Application No: AB/129/21/HH
Site Address: Fern Cottage 5A Surrey Street Arundel BN18 9DT
Description of works: Loft conversion to habitable use with 1 x rear dormer including the installation of 2 x front conservation rooflights. (This application may affect the character and appearance of the Arundel Conservation Area).

Thank you for your internet representation made on 26th November 2021 which has been recorded as an objection with the comments as follows:

OWPC42201

Existing North Elevation

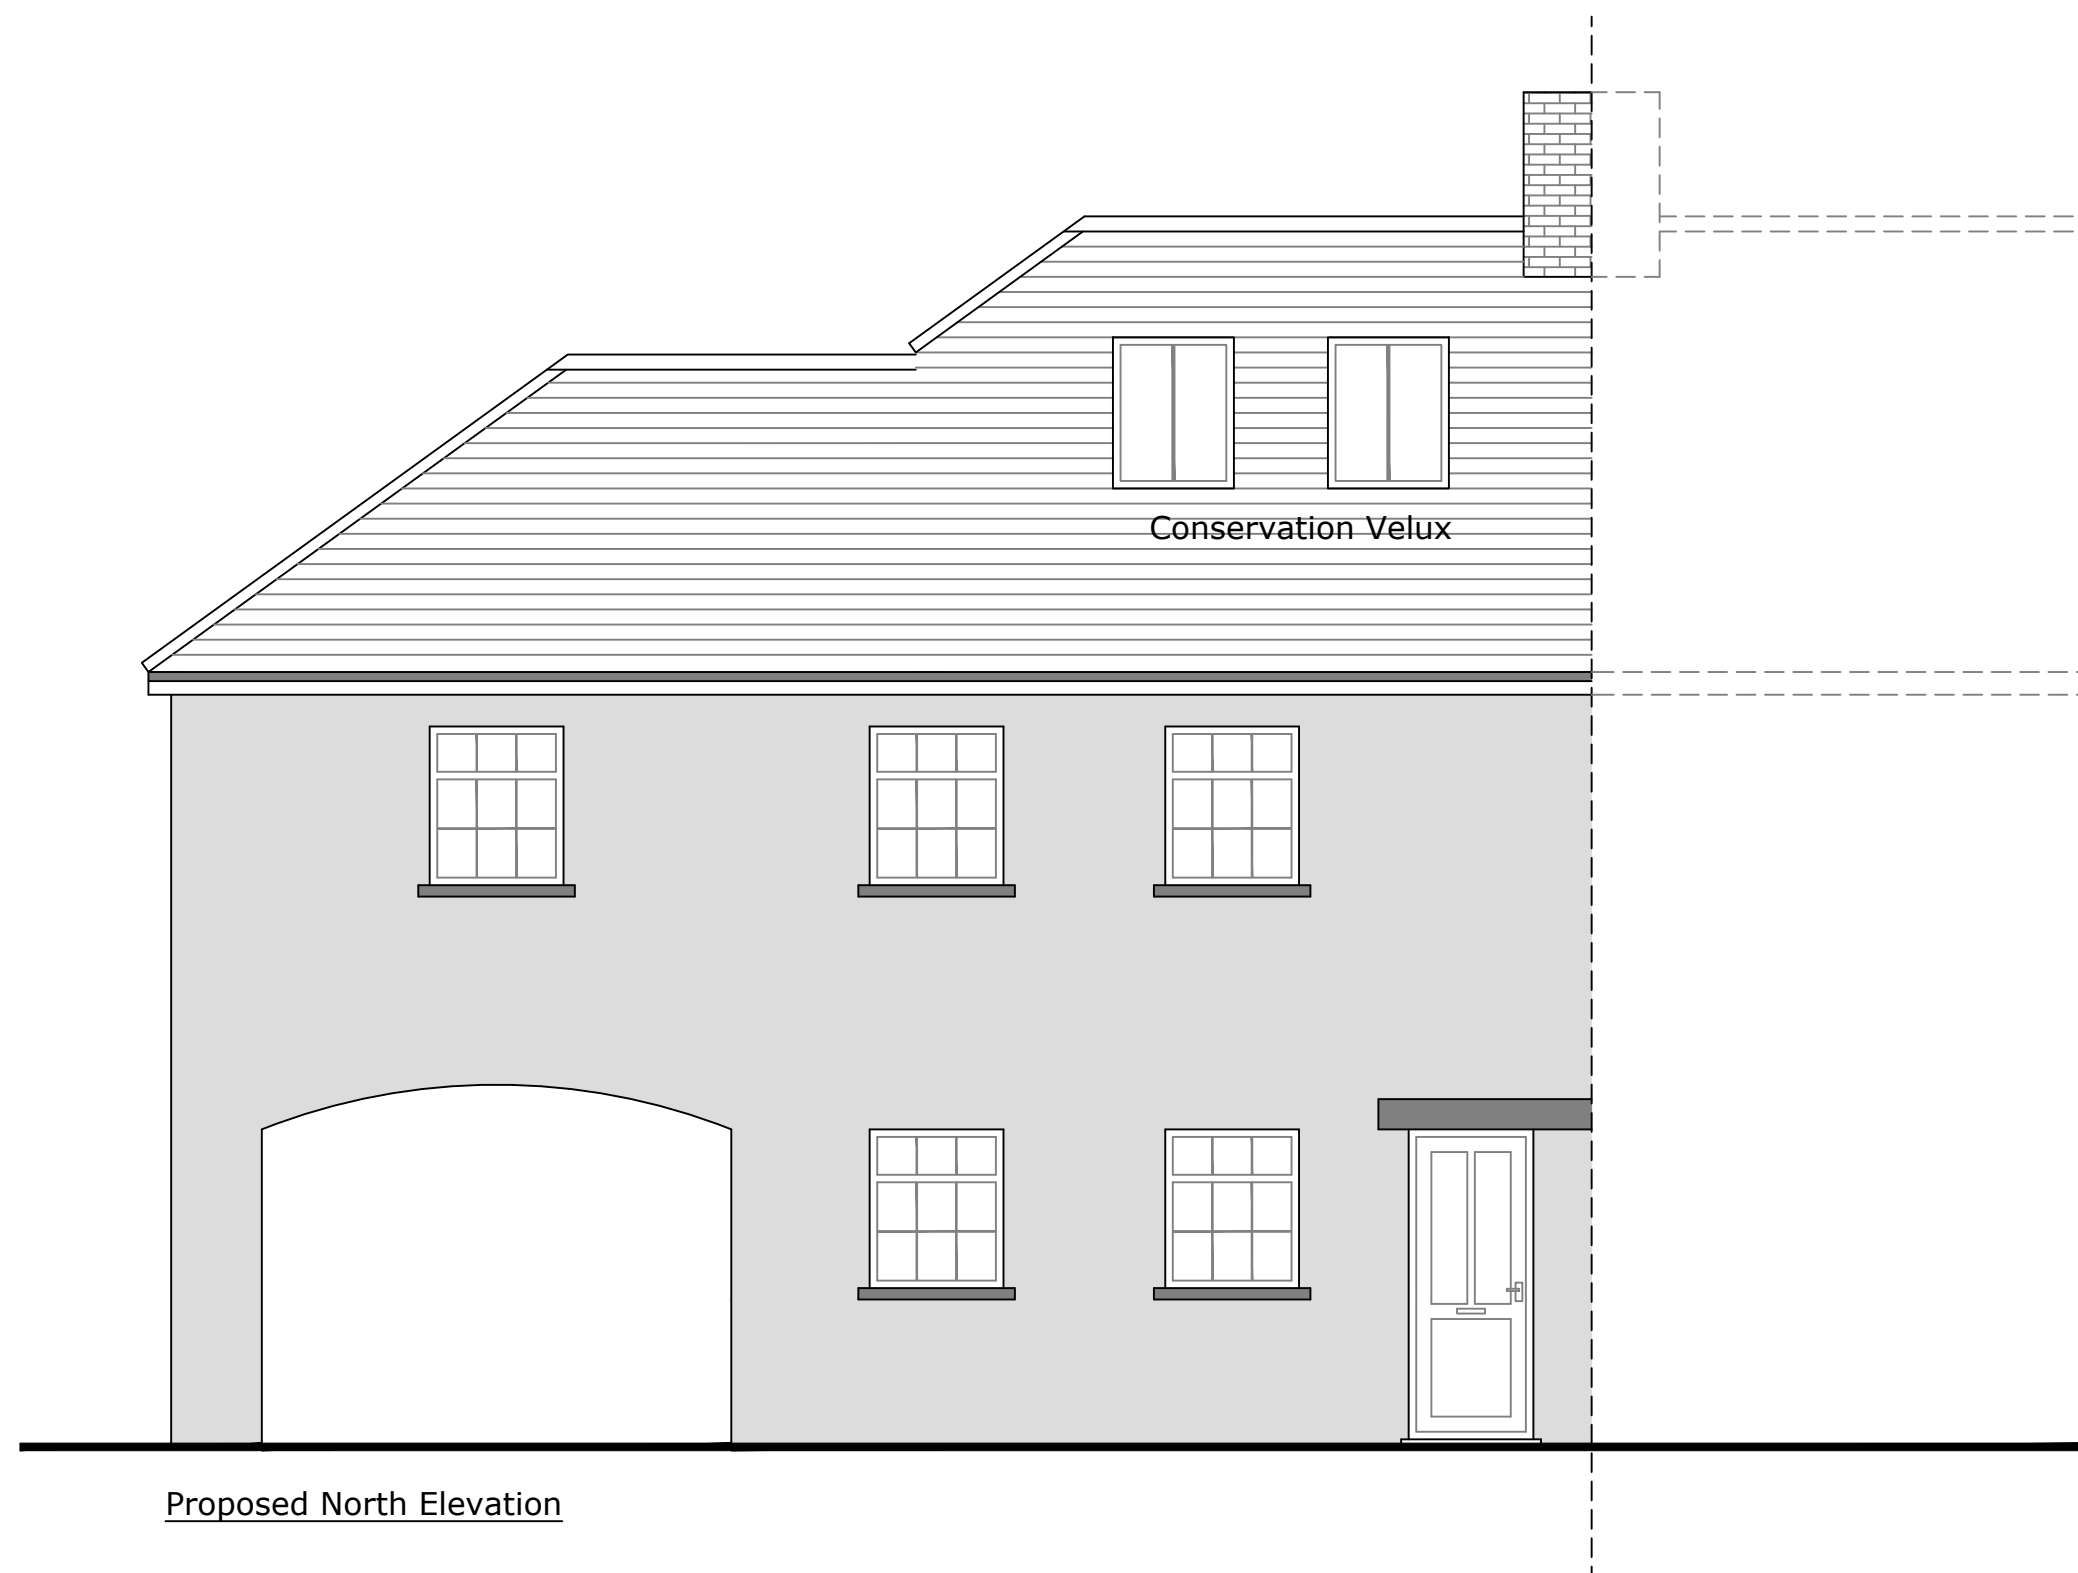
On the rear elevation a very large dormer extension is still proposed but which does not now involve a change in the existing roof profile as viewed from Surrey Street and School Lane. It is unlikely that the extension will be readily viewed from Surrey Street or The Slupe but that requires a detailed assessment by ADC.
